Your Ref: PP-2021-6786

RE: Bega Valley Shire Council response to request for the Secretary's Environmental Assessment Requirements (SEARs) from Auskelp Pty Ltd for the proposed Seaweed Aquaculture Lease, Disaster Bay - Eden 1.

Your ref: SSD-41680467

Subject: Major Projects – New Request for Advice – Seaweed Aquaculture Lease, Disaster Bay Eden 1 (SSD-41680467)

Figure 19
General Farm Layout with 17 long line sets (aligned horizontally) each separated by 6m with 25–28m of horizontal distance for anchorage.

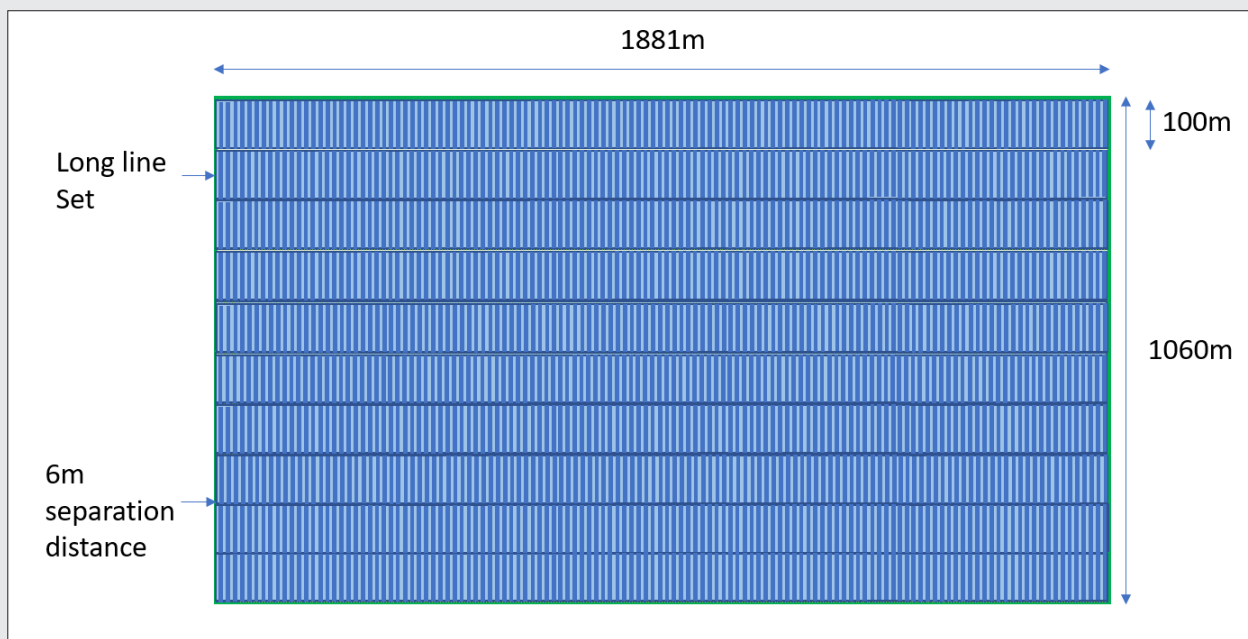
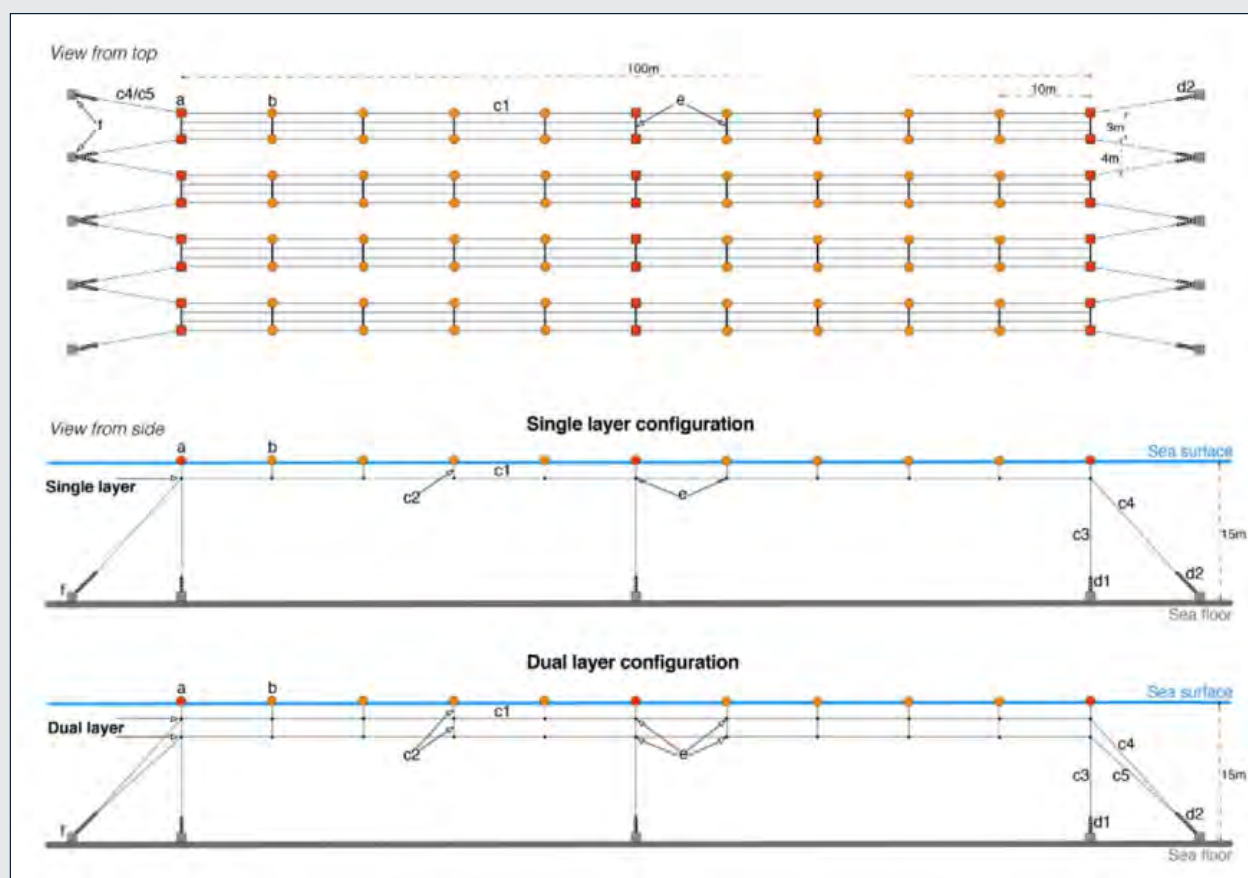
The EA will need to demonstrate that the proposed development and associated infrastructure is adequately designed to withstand extreme wave fields, coincident tidal ranges and associated currents and potential seabed changes expected within Disaster Bay. If infrastructure is damaged or destroyed during an extreme ocean storm event, there will need to be provisions for appropriate clean-up and remediation of the site.

The entanglement of Southern Right Whales and Humpback Whales (listed as Vulnerable in the BC Act), amongst other protected and threatened marine wildlife, is considered a high risk of this project and needs to be managed accordingly. A detailed marine wildlife threat reduction plan needs to be developed which should consider all species identified in the SEARs (and include managing potential encounters and entanglements of Southern Right Whales). Considerations could include an observer program, emergency response
